WALSH BAY ARTS AND CULTURAL PRECINCT

RESPONSE TO SUBMISSIONS

TZG RESPONSE TO HERITAGE COUNCIL SUBMISSION

NSW DEPARTMENT OF PLANNING & ENVIRONMENT

Figure 120: Proposed Hickson Road south elevation Shore Sheds, (alterations shown in blue).

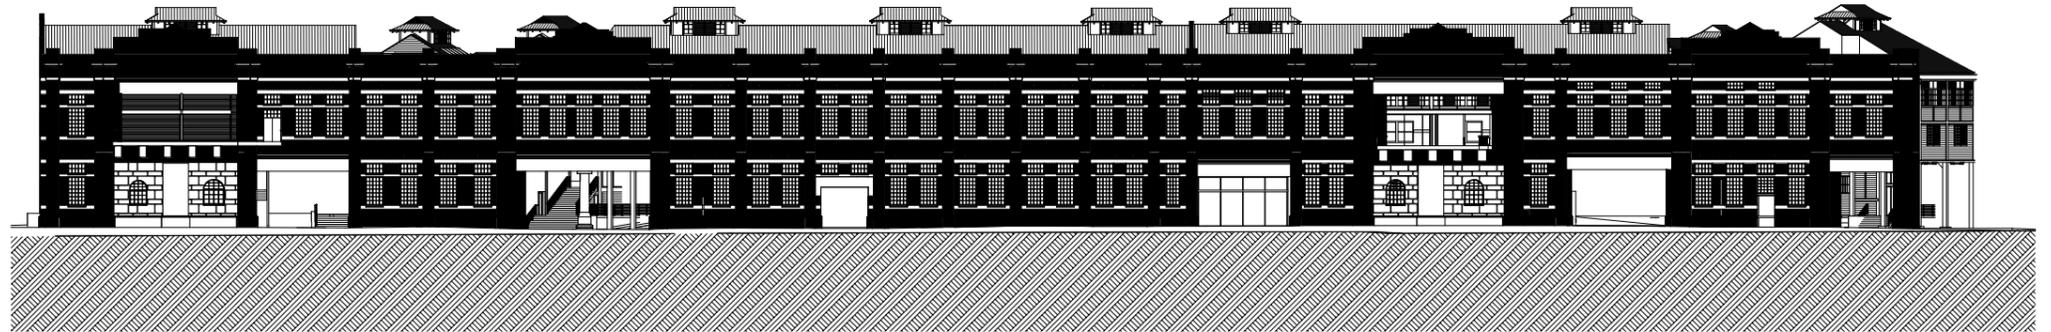
Heritage Council Comment 1 a)
The detailed design of building identification and wayfinding signage must be visually consistent and specifically designed to respect the integrity of the industrial character of the Precinct.

Response
A Signage and Wayfinding Strategy, prepared by Urban & Public, accompanies the proposal. It advocates signage that is consistent in design, is of a high standard of materials, construction and graphics and is appropriately located. The building identification and wayfinding signage will be visually consistent and respect the integrity of the industrial character of the Walsh Bay Wharf precinct.

An overview of the signage and wayfinding concepts approval is sought for is included in the revised Signage Plan overleaf, which rationalises the number of tenant identification signs within the Walsh Bay Arts and Cultural Precinct. The signs have been sized to relate to the original fabric of the wharves, and are hence different for Pier 2/3 and Wharf 4/5. The proposed signs are indicated in the perspectives to the right, shown in red for clarity, with the proposed digital walls marked orange.
